**March 16, 2023**

RE: SUB18-018 (RKK Construction Final Short Plat)  
Request for Information #2  
3633 90<sup>th</sup> Ave SE

The City of Mercer Island Community Planning and Development Department has performed a review for compliance with the zoning code, Title 19 of the Mercer Island City Code (MICC) for the above-referenced Final Short Plat application. The following issues need to be addressed before we can continue processing of the application:

**WALLACE PRELIMINARY SHORT PLAT
MERCER ISLAND SHORT PLAT NO. SUB18-008**

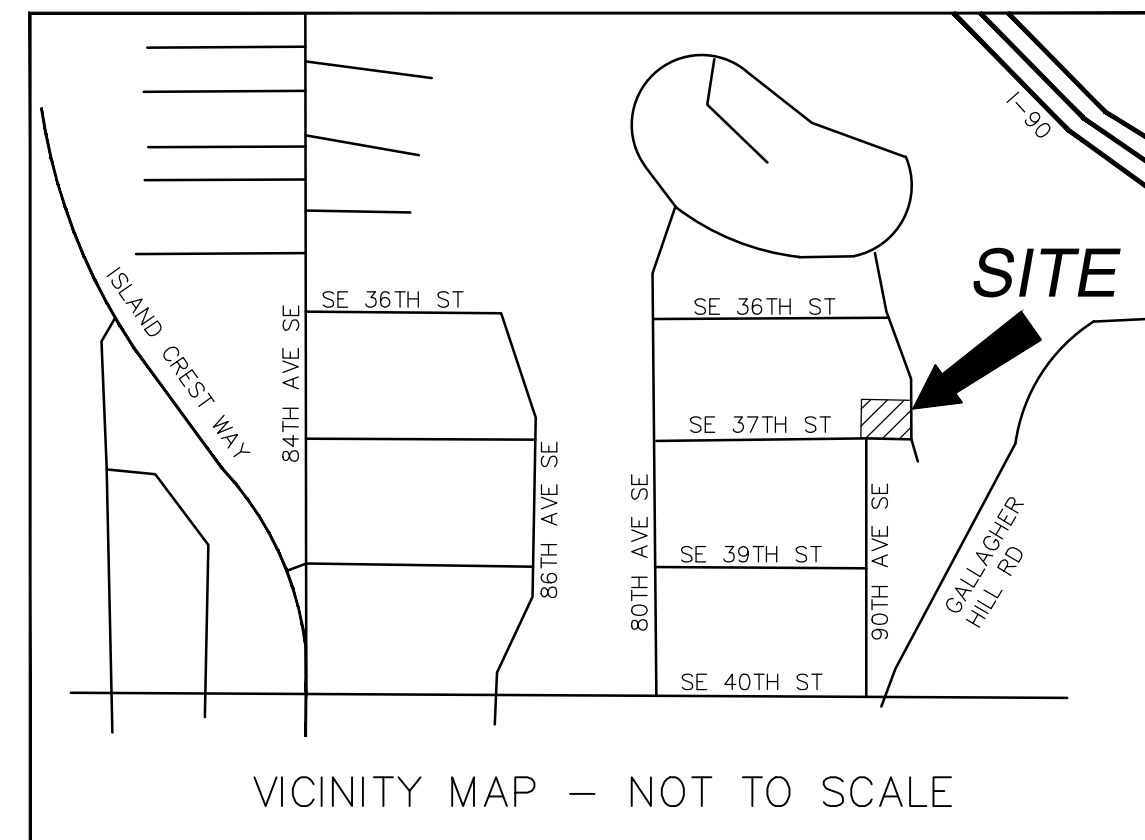
1. Please update the title of the Short Plat to account for the change in ownership. Please also remove the word "Preliminary" from the title as this review is for the final plat, not the preliminary approval. **Changed to RKK.**

2. Condition 15 of the preliminary short subdivision for this project requires that six notes be shown on the face of the plat. The following notes were printed incorrectly on the face of the plat and need to be corrected (corrections shown in **bold type** below):

- i. Note B: "The monitoring, cleaning, maintenance and repair of storm drainage systems in accordance with City Ordinance No. 95C-118 is required for all lot owners within this Plat to control stormwater runoff and control erosion and flooding downstream. All costs related to stormwater runoff **control** shall be borne by the owners of each lot in equal share. This obligation shall be recorded separately with each individual lot sale and shall travel with the land." **Changed.**

- ii. Note D: Prior to the issuance of a building permit, each application shall be accompanied with a temporary erosion and sedimentation control plan, clearing and grading plan, access and utility service plan, a landscape plan (which shall identify existing vegetation to be retained, limits of all clearing and grading), and a schedule for the construction. The applicant's Civil Engineer, experienced in soils geology and mechanics, shall review the proposed site and building construction and provide recommendations that will limit site disturbance, minimize risk of soils movement, evaluate site slope stability and define materials and construction practices for **the work**. The Building Official may require that the Engineer be present during construction, monitor the work, and recommend special techniques or

mitigating measures. The costs associated with the Engineer's monitoring and mitigation measures shall be borne by the applicant. **Changed.**

These notes must be added to the face of the plat before the city approval.
